**RE: Curia Building Addition  
34401 Alexander Blvd. NE Albuquerque, NM 87107  
Grading and Drainage Plan (F16D003B1)  
Engineers Stamp Date 10/25/2022**

Re: Curia Building Addition  
4401 Alexander Blvd NE Albuquerque, NM 87107  
Grading and Drainage Plan (F16D003B1)  
Letter of Response

On behalf of Curia New Mexico LLC (f/k/a Oso Biopharmaceuticals, LLC), Burns & McDonnell is pleased to submit this Letter of Response to the Grading and Drainage Plan (F16D003B1) comments received September 20, 2022. Response to comments are located below in italics and on enclosed drawings.

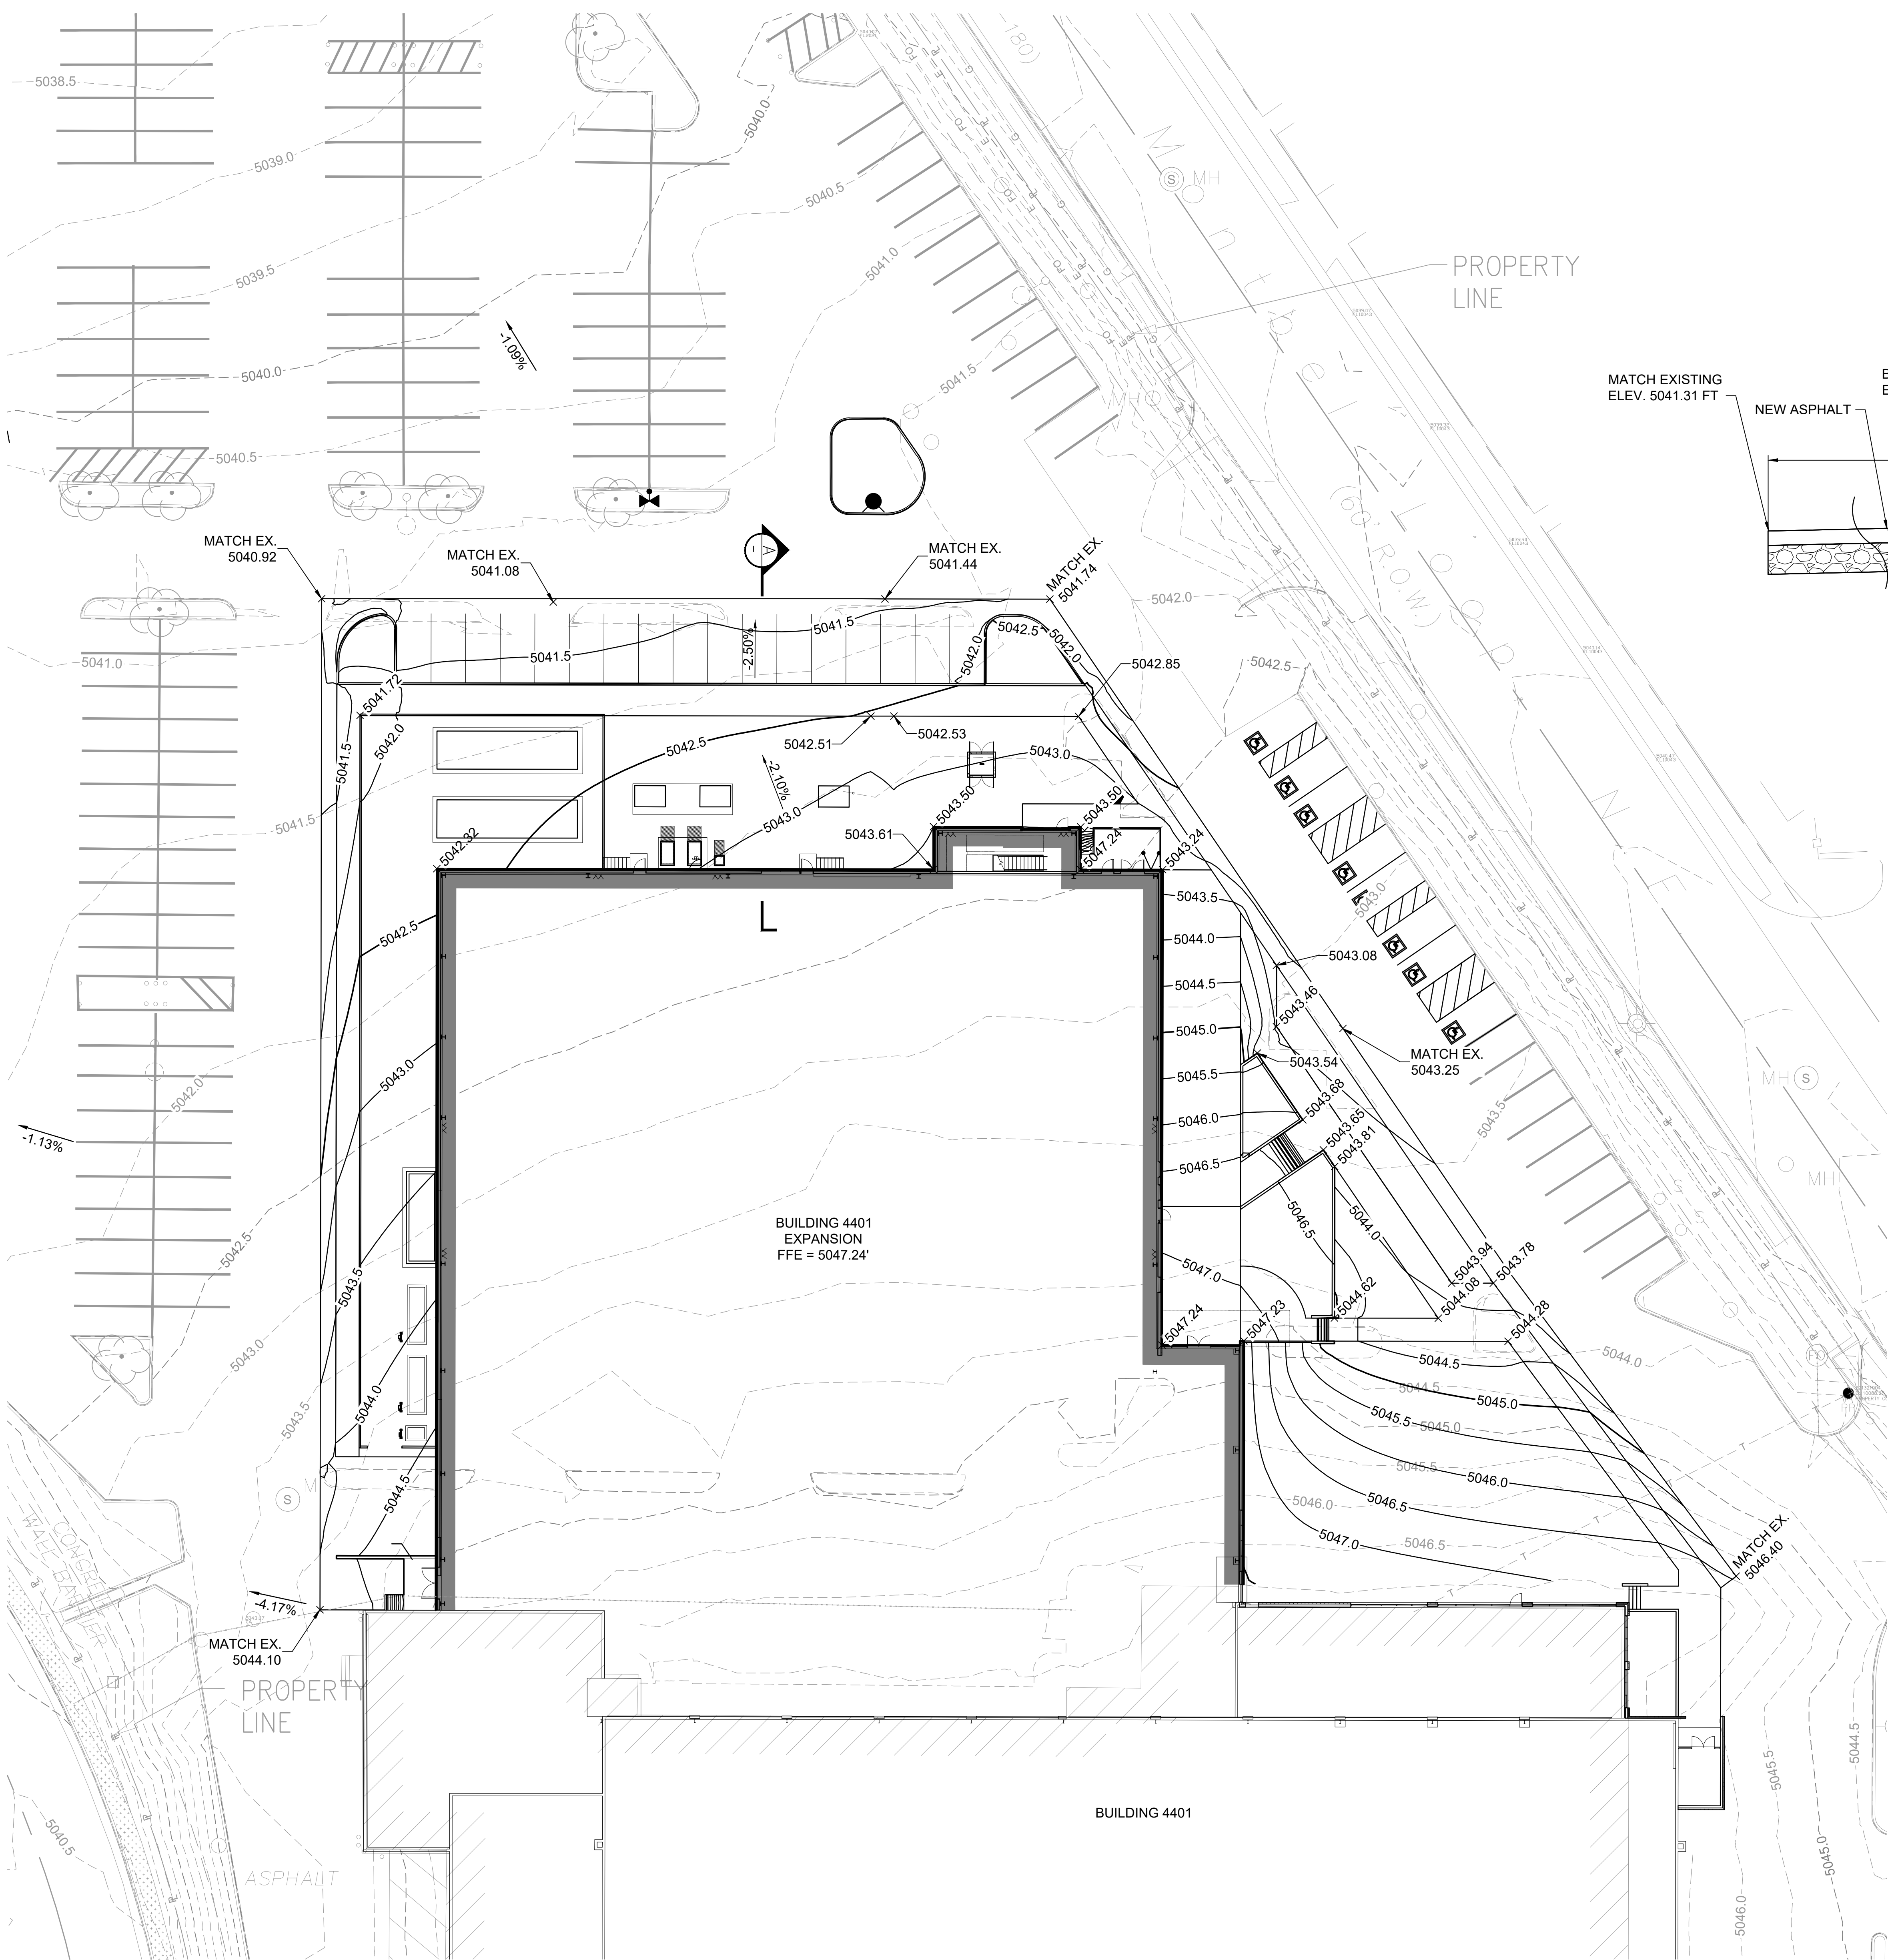
- 5) First Flush Volume requirement calculations must be provided. How will the first flush volume requirement be handled?  
*First Flush Volume calculations are included in CG101 Overall Grading & Drainage Plan. The existing / proposed detention pond retains the First Flush within*

*the volume from bottom of pipe to bottom of pond.*

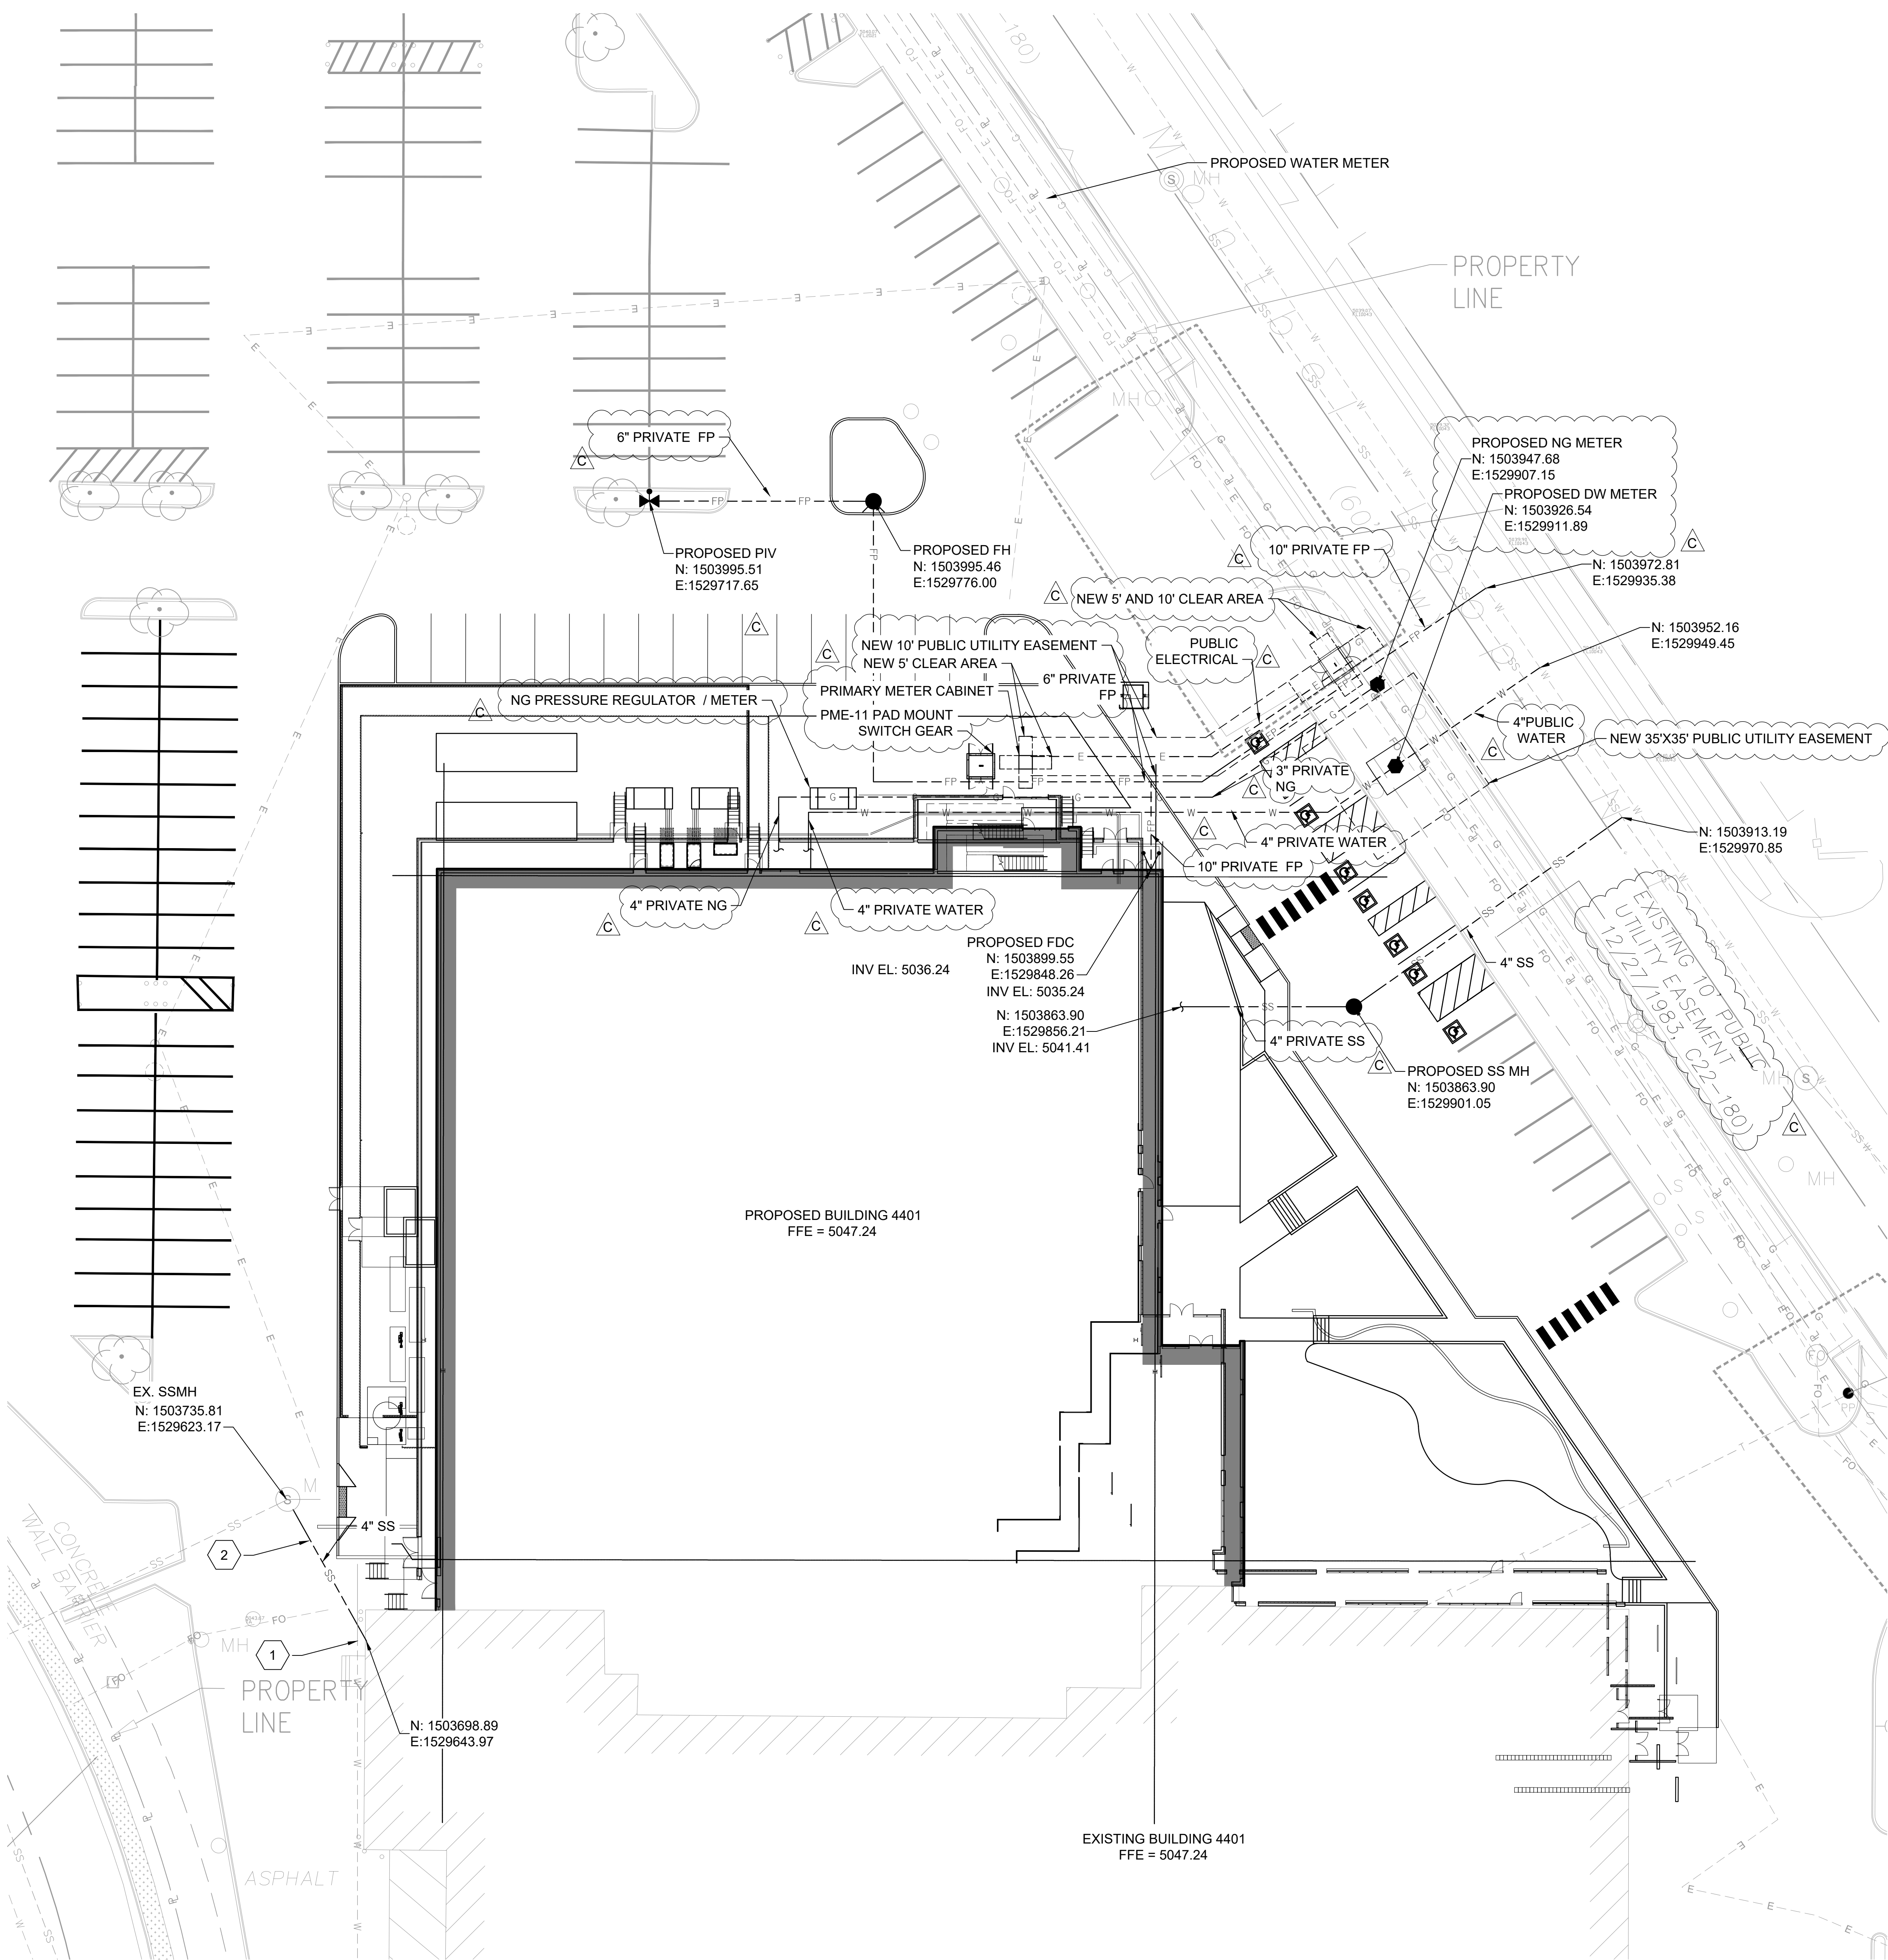
- 4) Provide detail elevation and finished contours around the building and beyond to show how it will tie to the existing grades. To the north the Finished Floor elevation is nearly 6' about the exiting grade. Are there going to be stem walls. Provide cross-sections.  
*Finish grade and cross section are included on drawing CG102 Enlarged Grading & Drainage Plan.*
